Application by Highways England for an Order Granting Development Consent for A57 Link Roads

Deadline 4 - response on behalf of High Peak Borough Council

Responses from High Peak Borough Council are provided in red to outstanding matters discussed in the hearing session held during the week commencing 7th February 2022.

- LEGEND**
- MODELLED QUALIFYING FEATURES AND PUBLIC ACCESS
  - DEFRA PCM LINKS COINCIDING WITH ROADS MEETING THE DMRB LA105 TRAFFIC SCREENING CRITERIA
  - ROADS MEETING DMRB LA105 TRAFFIC SCREENING CRITERIA

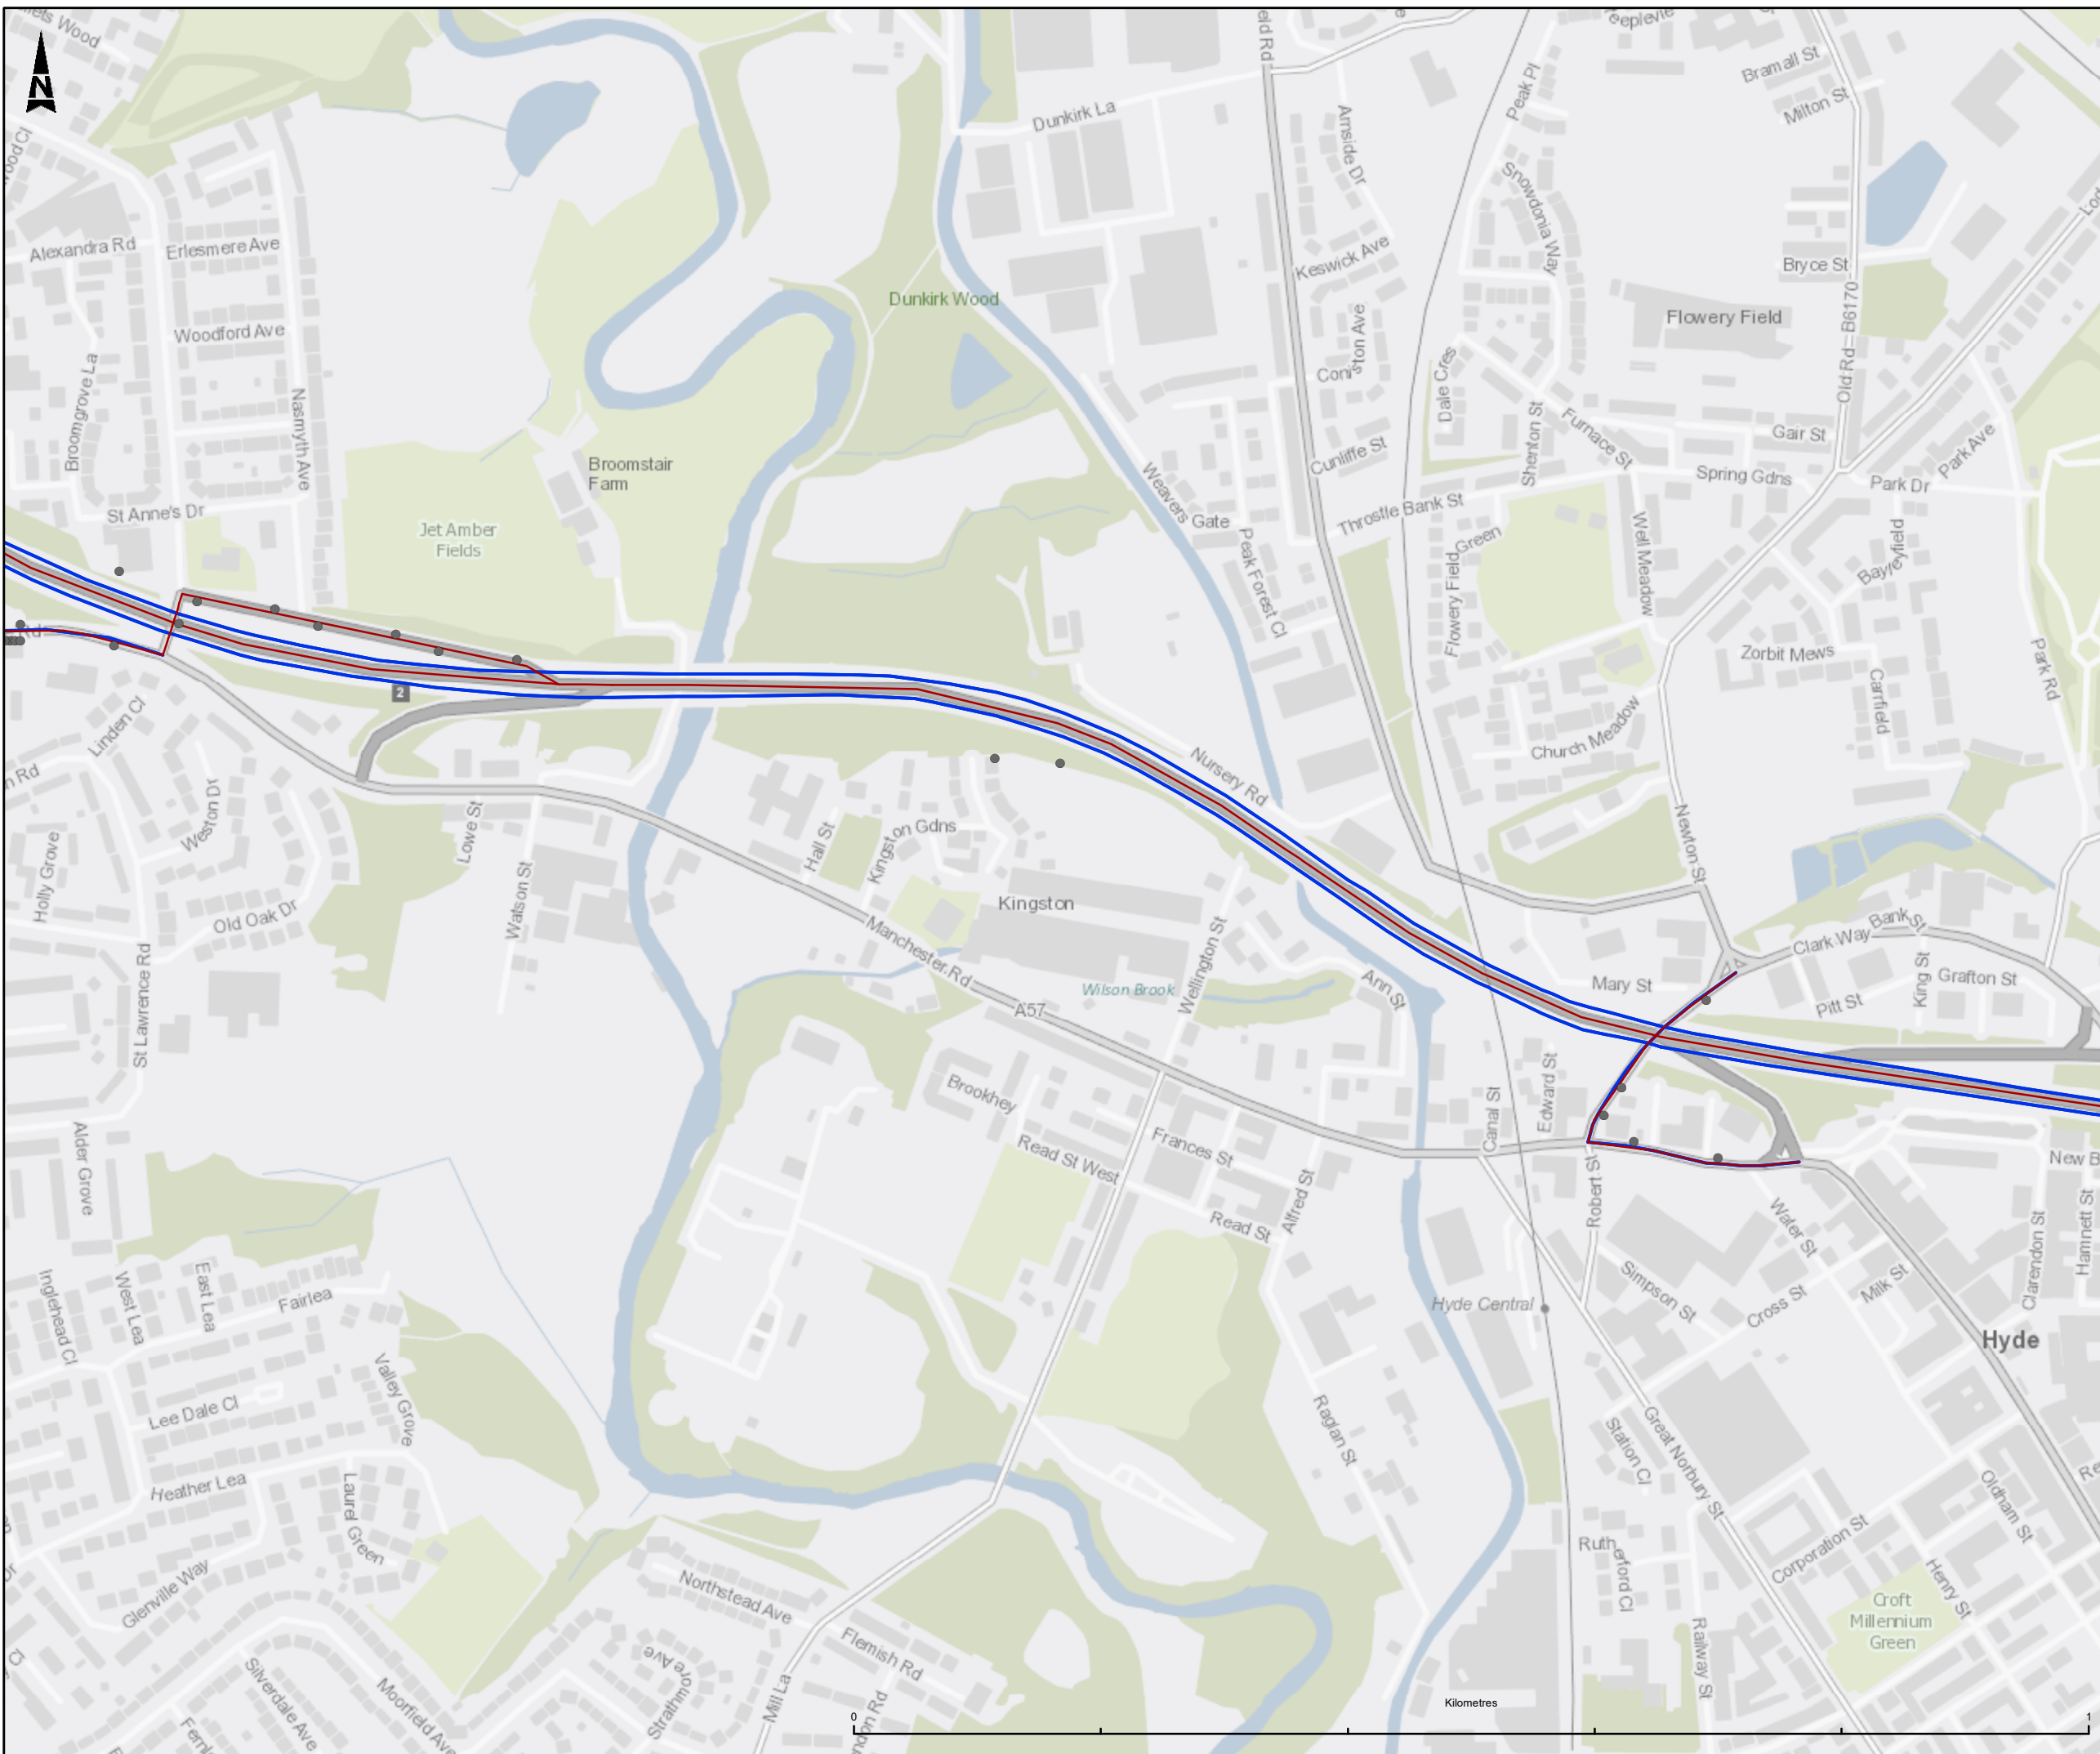
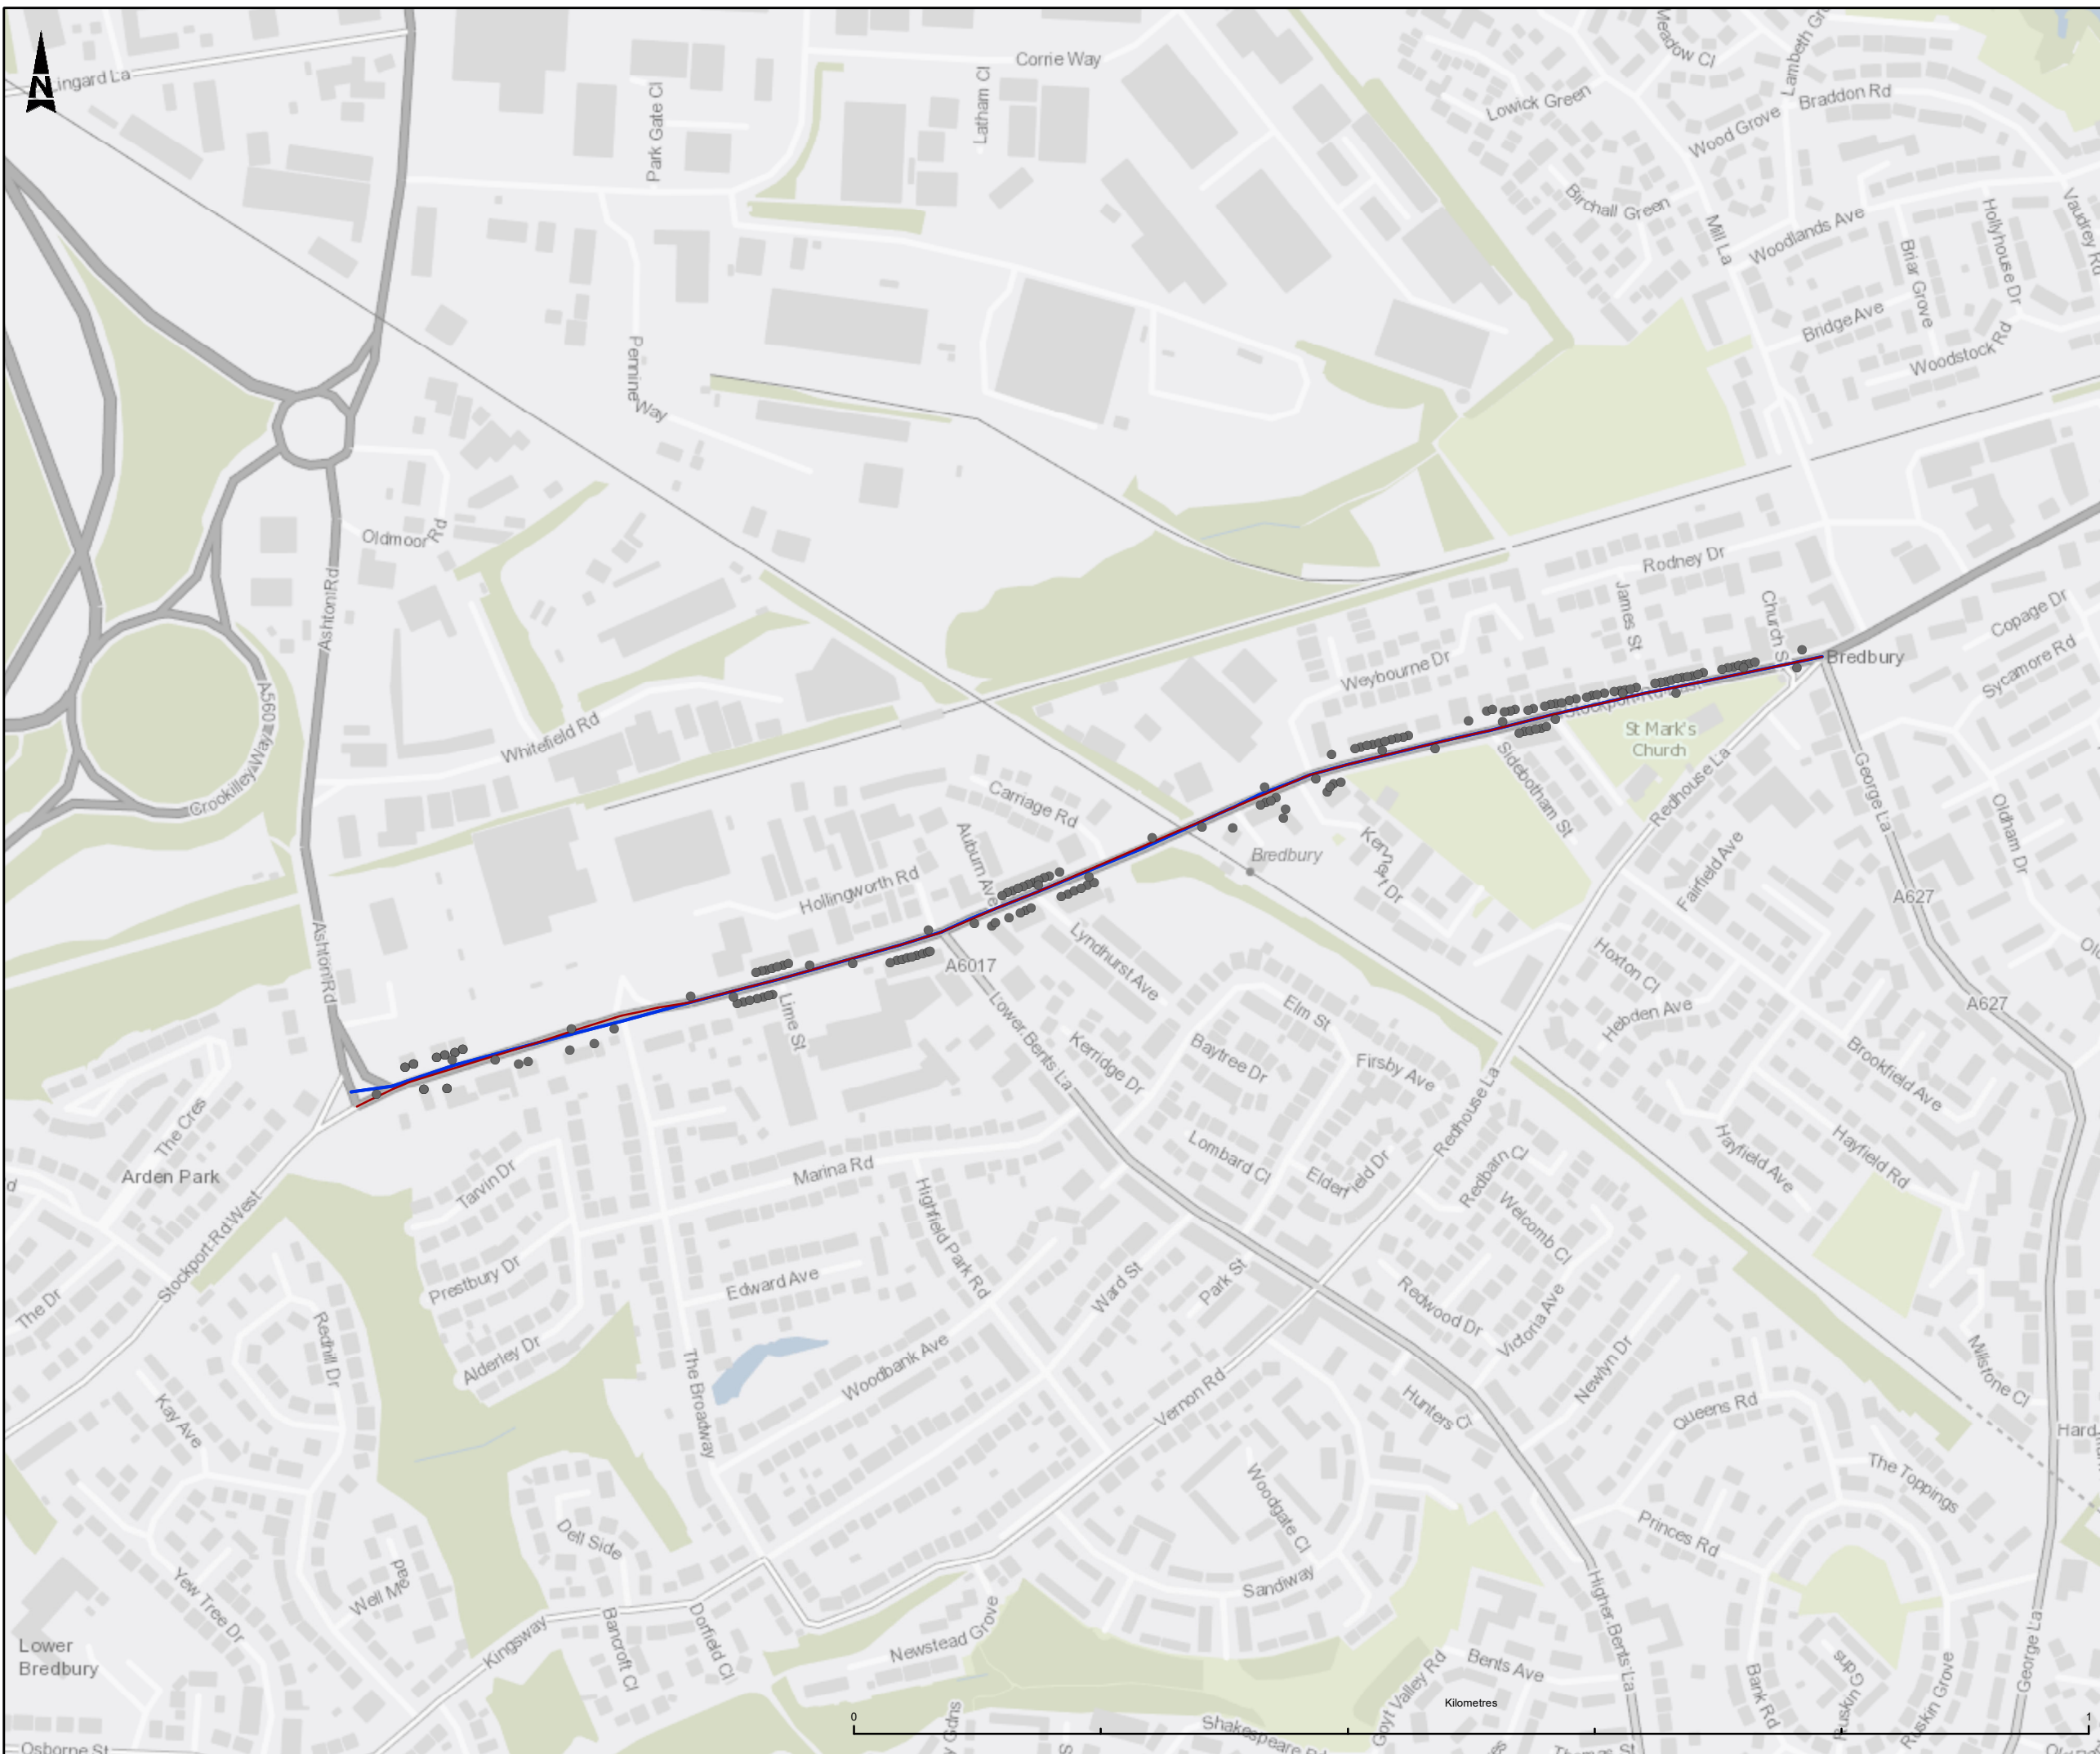
8.38 aa	Response is accepted with regards the details of dust control measures being set out in the EMP Nuisance Management Plan which will form an annex of the EMP (second iteration). The response however does not cover the second part of the issue, 'Qualifying features for the compliance assessment and receptors considered in the local air quality assessment along the A57 Brookfield are expected to show a large increase in NO2 concentrations in the opening year. The qualifying features for the compliance assessment are not labelled on Figure 5.4'
